An
Bord
Pleanála

Inspector's Report ABP-311482-21

Whether internal and external works to an apartment building constitutes development and if so whether that development can be considered exempted development.

Apartment Q, Coliemore Apartments,
Dalkey, Co. Dublin.

PHOTOMONTAGE NO. 2

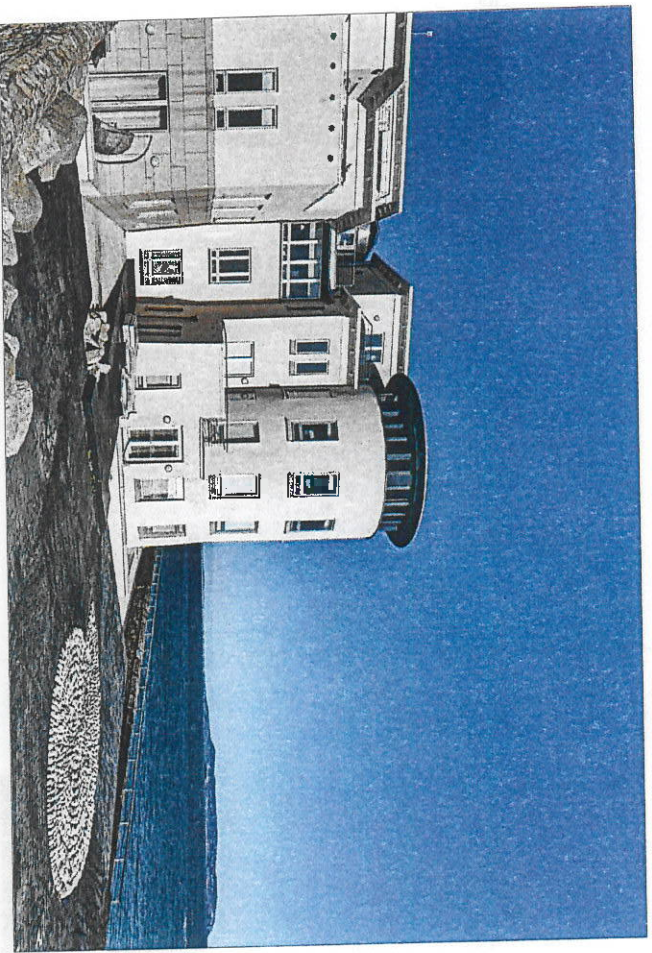
- 8.8.3. The drawings/images submitted showing the existing and proposed elevations/photomontages indicate that there would be no change to the size or colour of the existing opening. It would simply be changed from a window to a door. It should be noted that there is another existing door access to this terrace and, therefore, the proposed works would not create a new external amenity space. The fenestration division would simply be altered to accommodate the double doors.

- 8.9.3. The drawings/images submitted showing the existing and proposed elevations/photomontages indicate that there would be no change to the size or colour of the existing openings. It would simply involve changes to the fenestration division by the omission of some mullions and a low-level transom.

WORKS ITEM 8

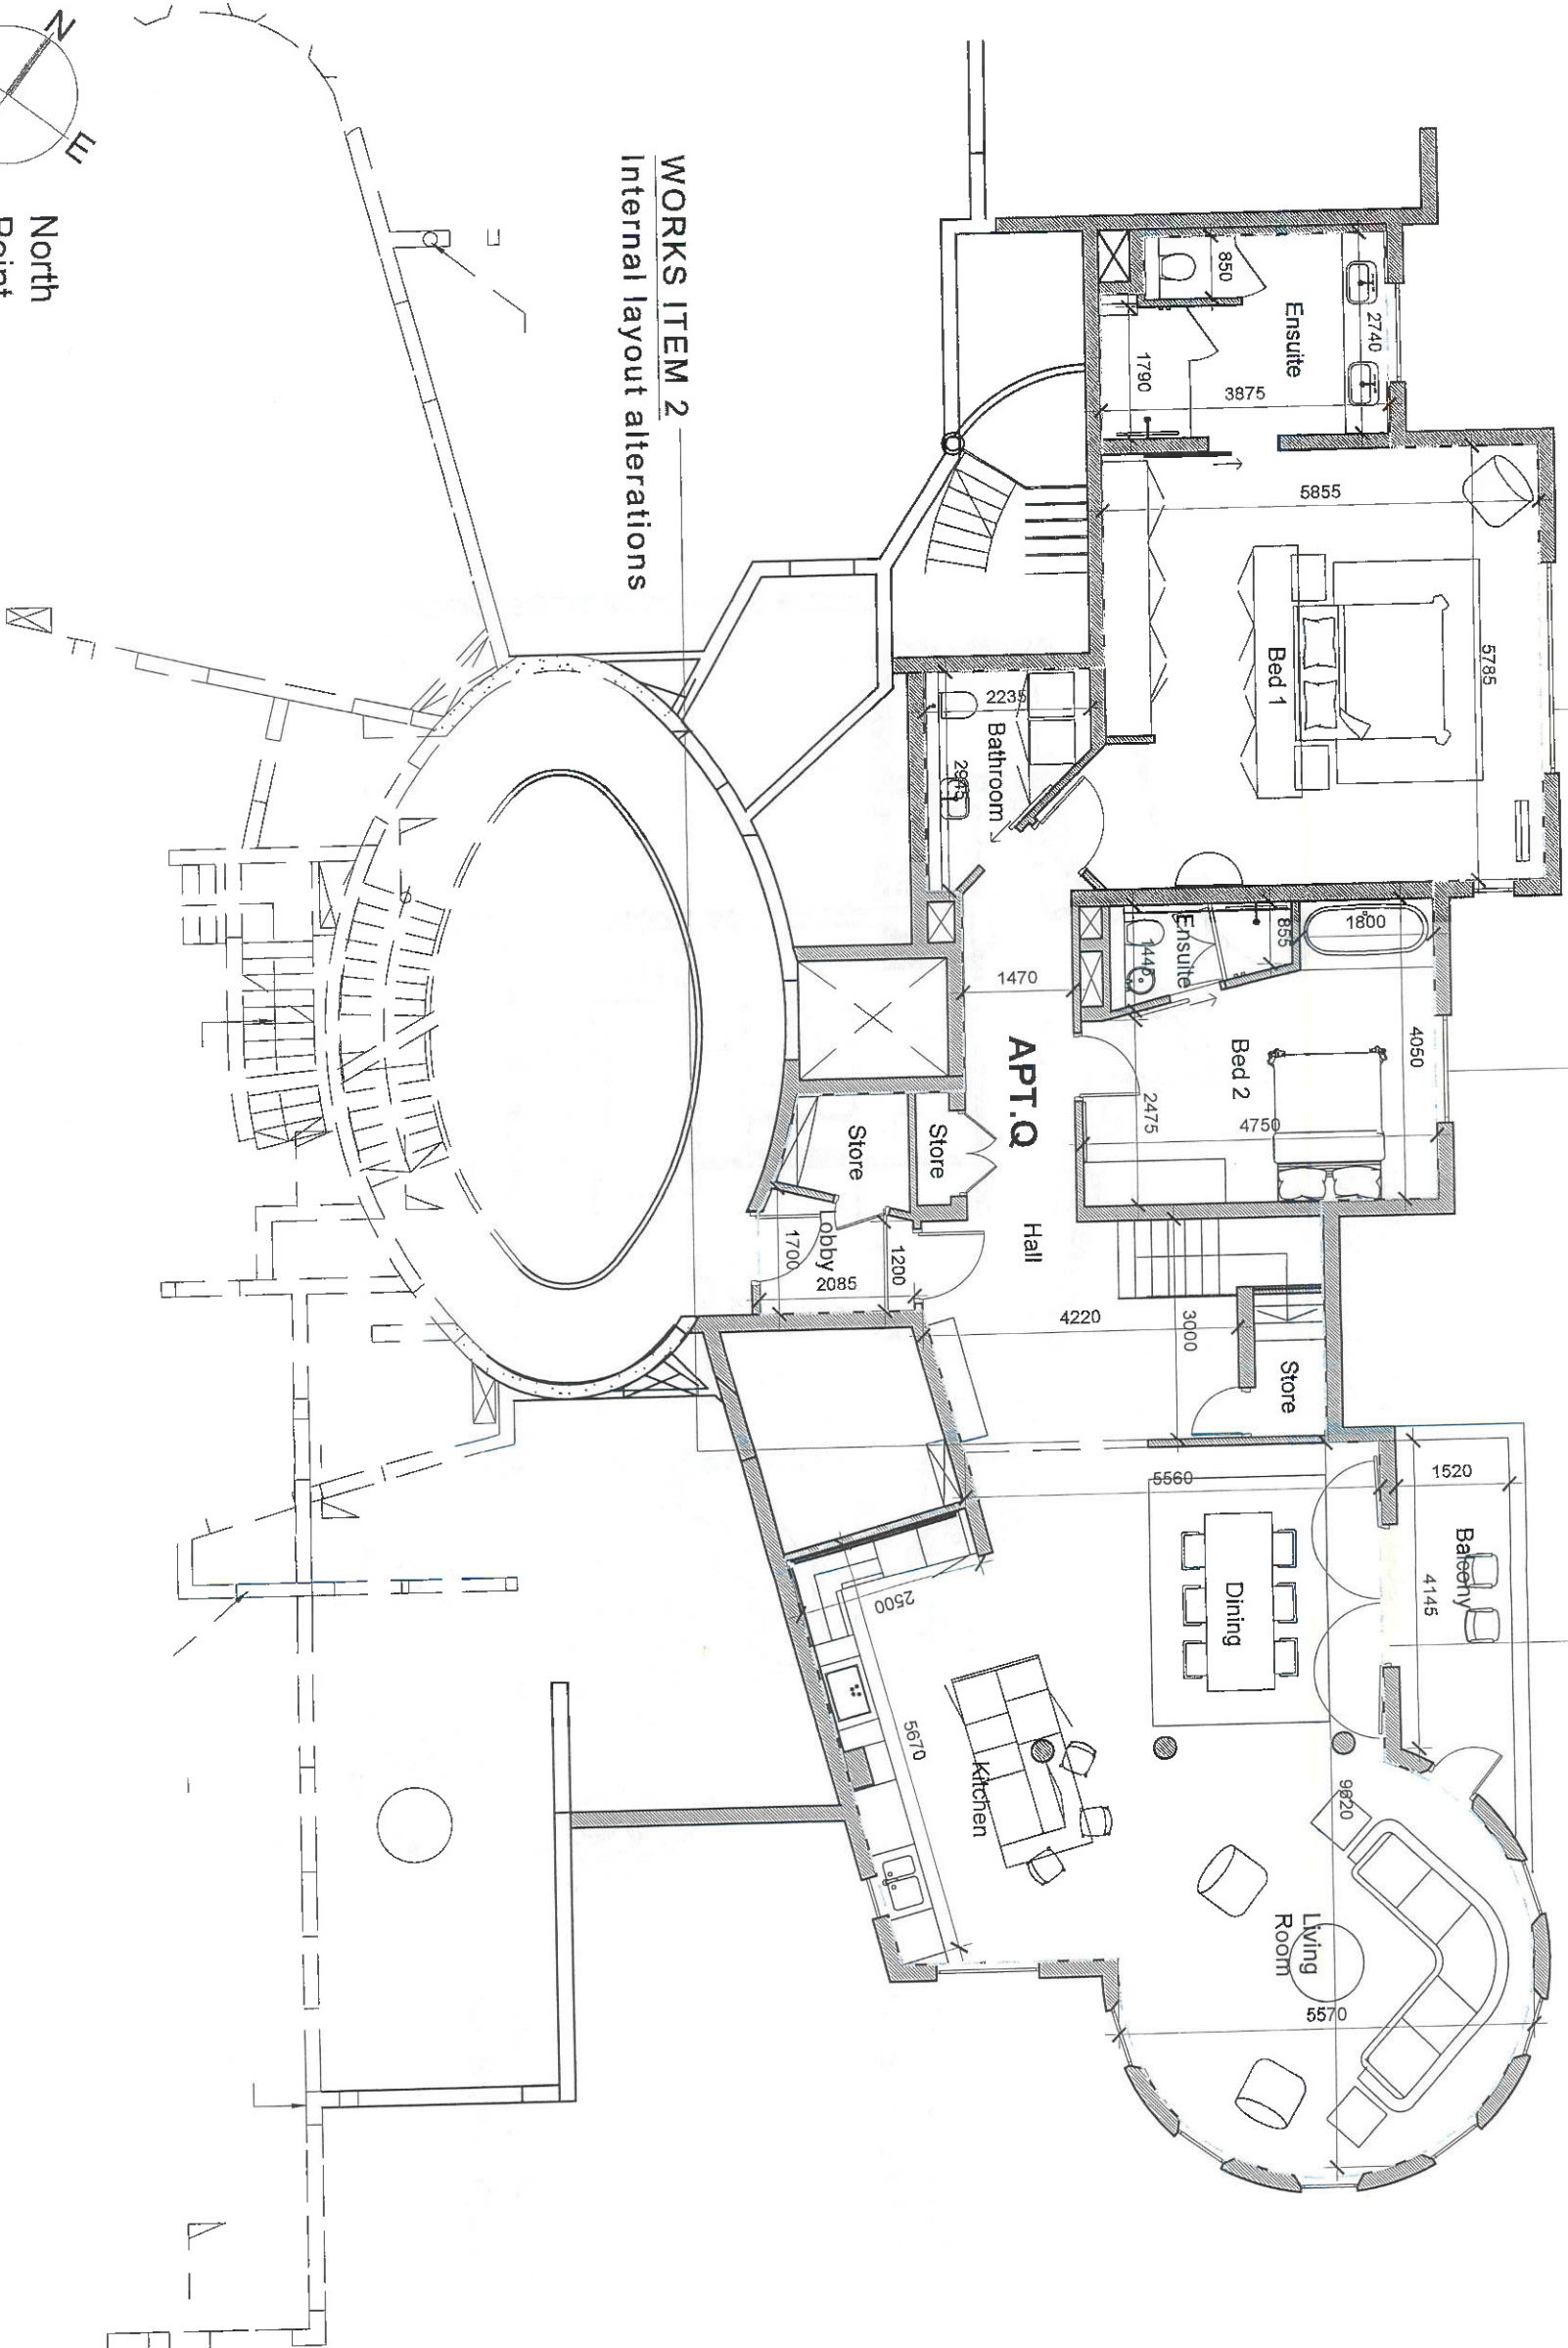
8.9. **Item 8**

- 8.9.4. I consider these to be minor alterations given the limited extent of the works and the wide variety of window sizes/styles that exist on the rear elevation. Again, the alterations would only be marginally perceptible from sea views. I do not consider that these alterations would materially affect the external appearance of the structure so as to render the appearance inconsistent with the character of the structure or any neighbouring structures.

- 8.9.5. Accordingly, I am satisfied that Item 8 would be exempted development in accordance with the provisions of s. 4(1)(h) of the Act.

WORKS ITEM 5
Rotunda fenestration changes
+ Lowering of sill

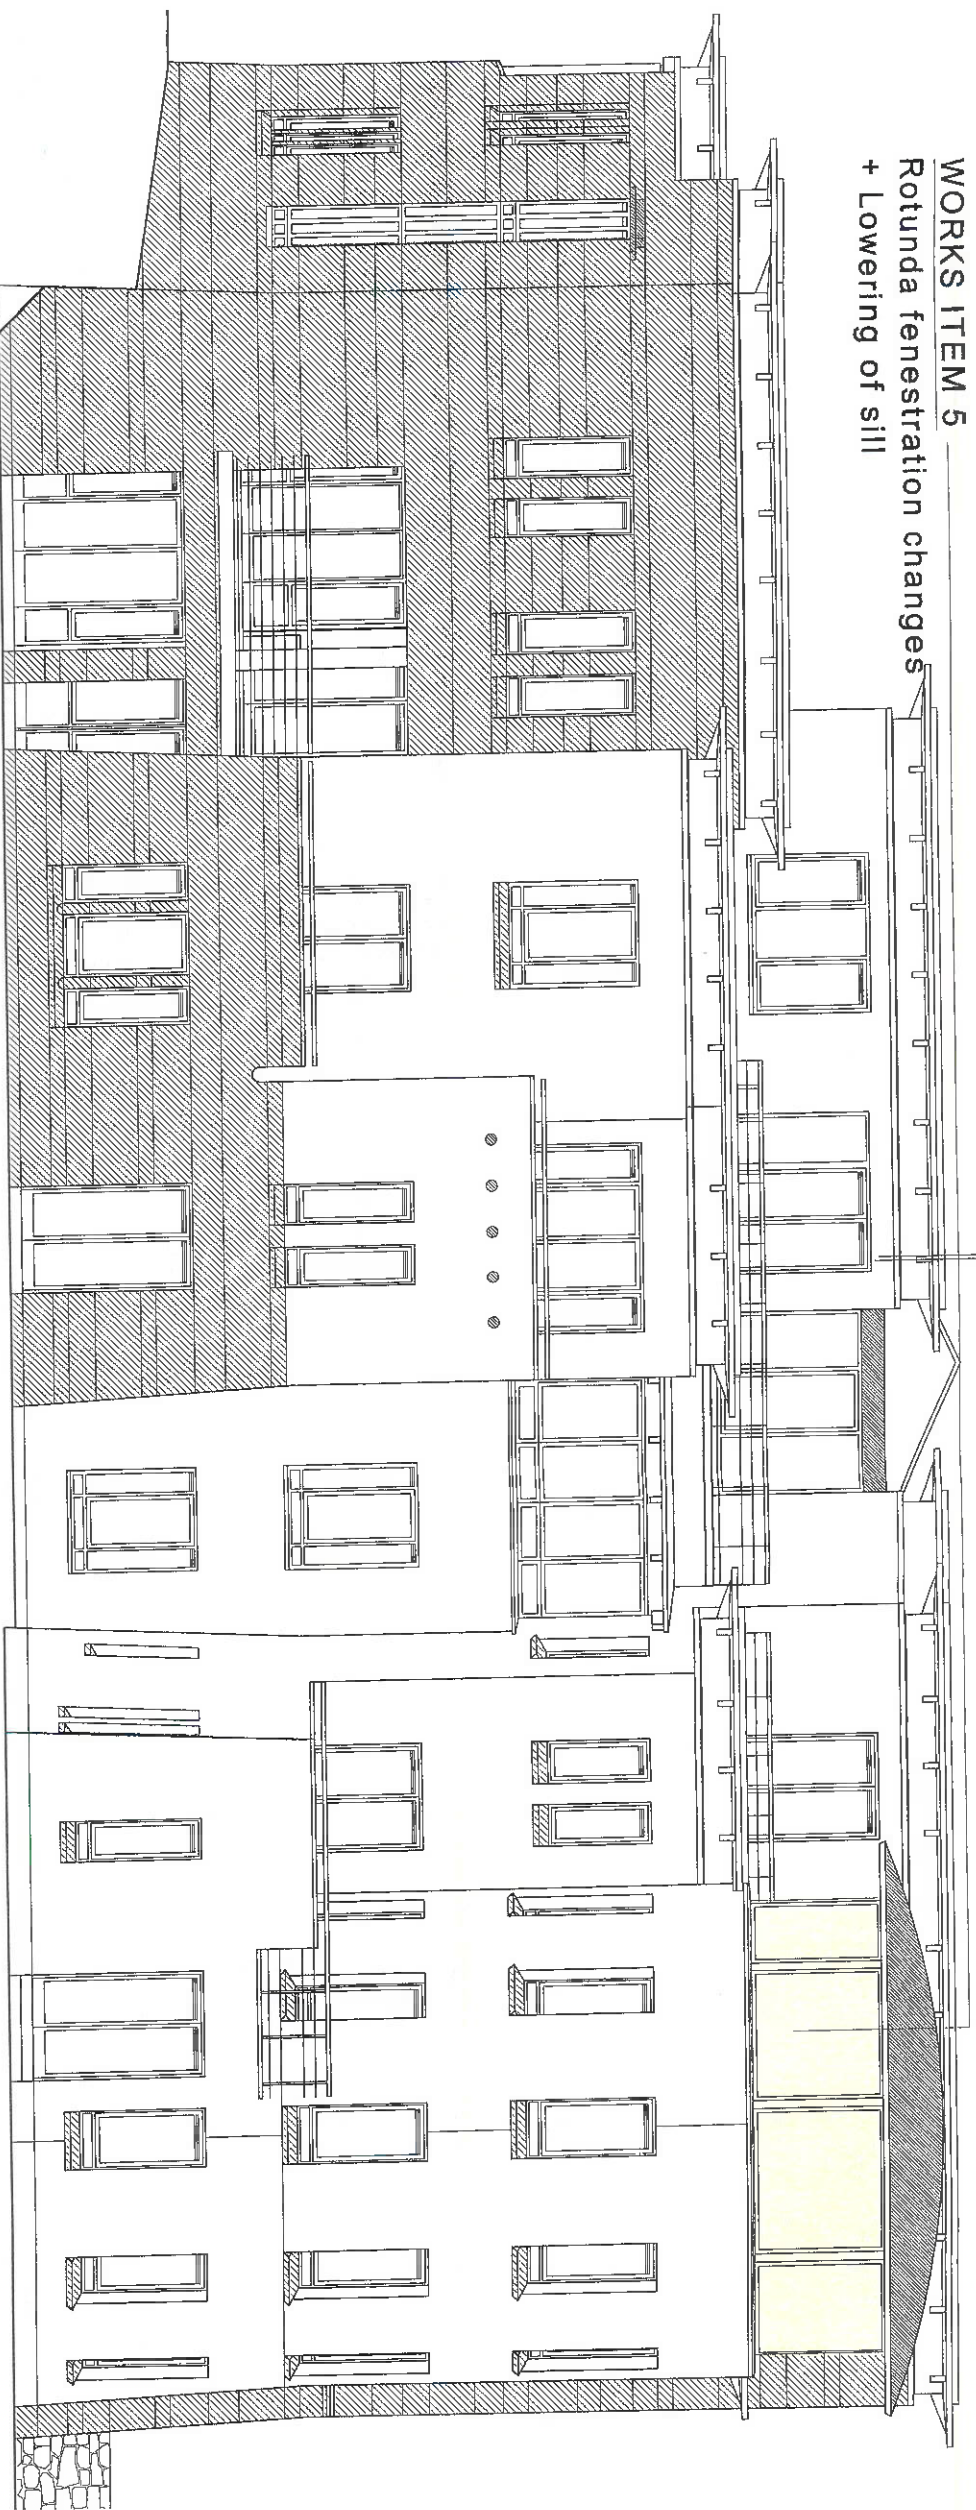
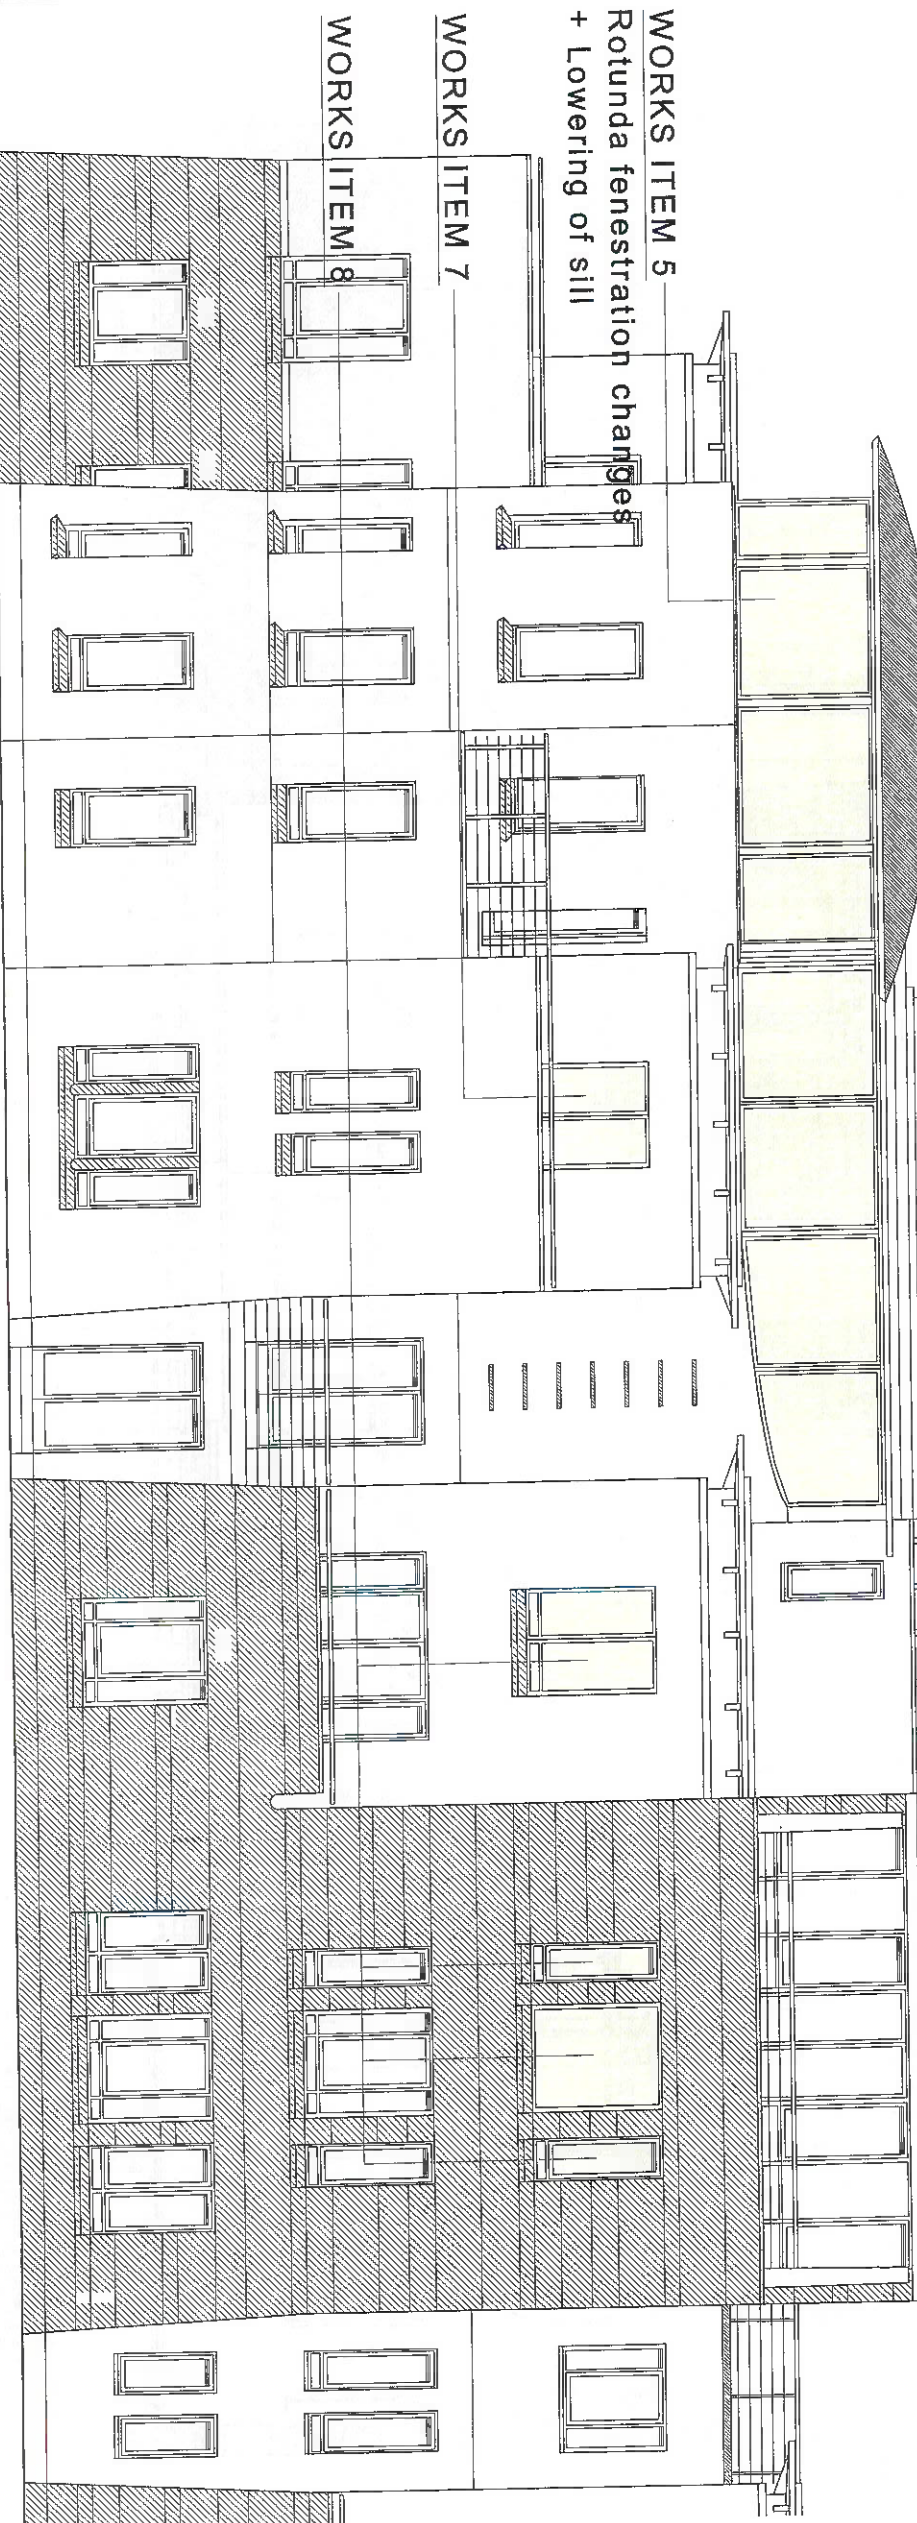
8.6. Item 5 - Rotunda fenestration changes and lowering of sill

8.6.3. I have concluded that the individual elements of Items 3 & 4 do not materially affect the external appearance of the structure so as to render the appearance inconsistent with the character of the structure or of neighbouring structures. Item 5 involves a combination of Items 3 & 4 and therefore effectively requires an assessment of the cumulative impact of the works.

8.6.4. I have considered the cumulative impact of the lowering of the rotunda sill level and fenestration changes at 3rd floor level. Again, having regard to the existing distinctive character of these features, their limited visibility, and the limited extent of the proposed alterations, I do not consider that these cumulative alterations would materially affect the external appearance of the structure so as to render the

8.6.5. Accordingly, I am satisfied that Item 5 would be exempted development in accordance with the provisions of s. 4(1)(h) of the Act.
